Addendum No. 1

RE: Contract # C204260

Dare County (Sound Class Tug)

Construct 70'-6" X 30' X 11' Sound Class Tug

RUBBER FENDER & TIRE LAYOUT

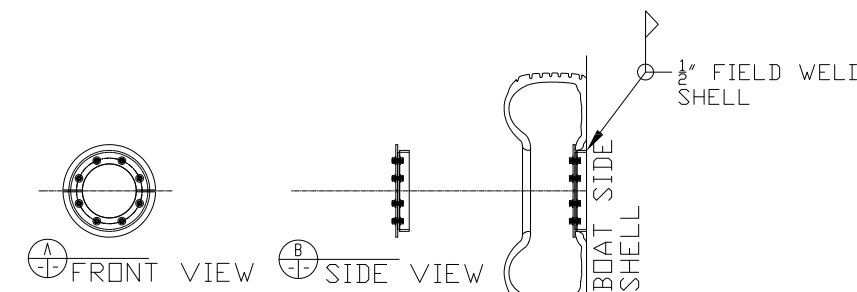
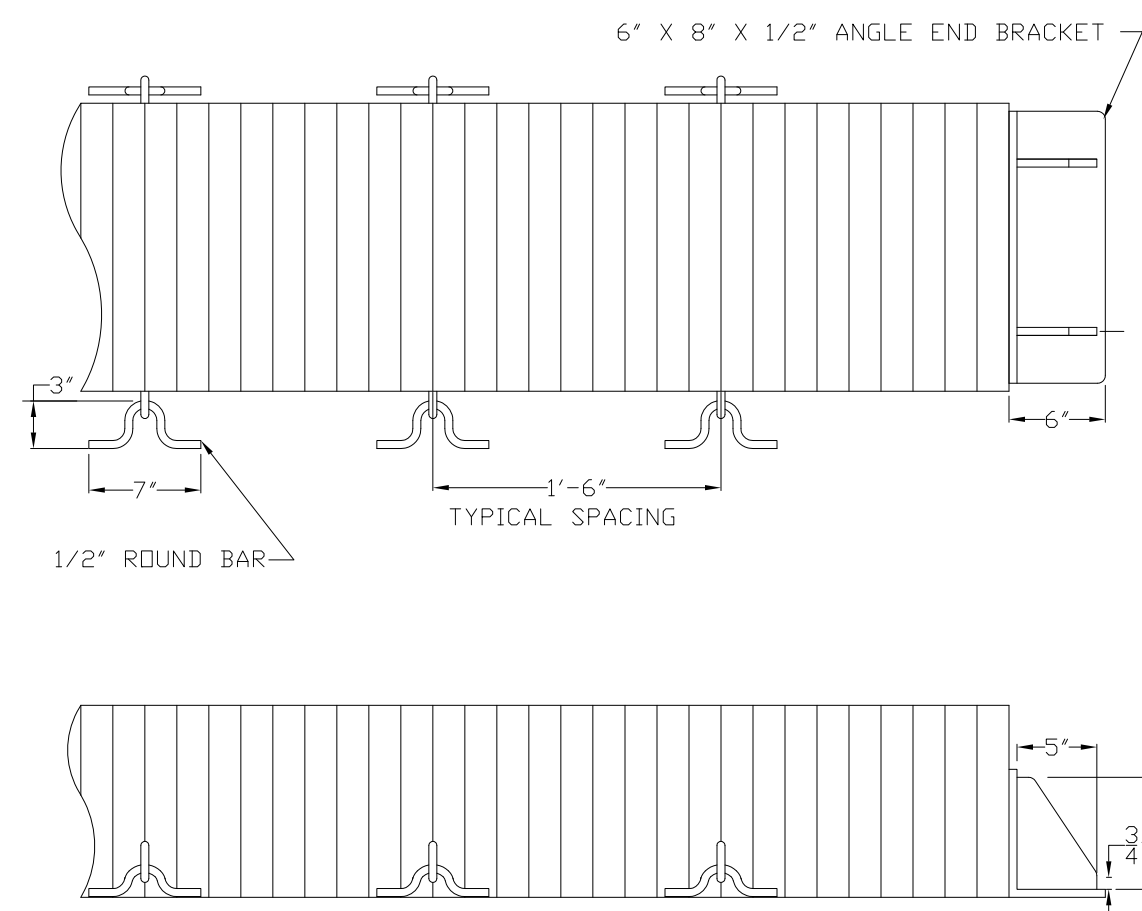
Sheet No.	Revisions
17-1372-528 Sheet 1	Changed name of Drawing to Sewage and Greywater Piping. Removed Manufacturer from MSD and Pump. Added 200 gallon Zero Discharge Holding Tank in Bill of Materials.
17-1372-528 Sheet 2	Changed name of Drawing to Sewage and Greywater Piping. Greywater rerouted to drain directly overboard
17-1372-684	Revised Detail A & B – Tire Mounting Details
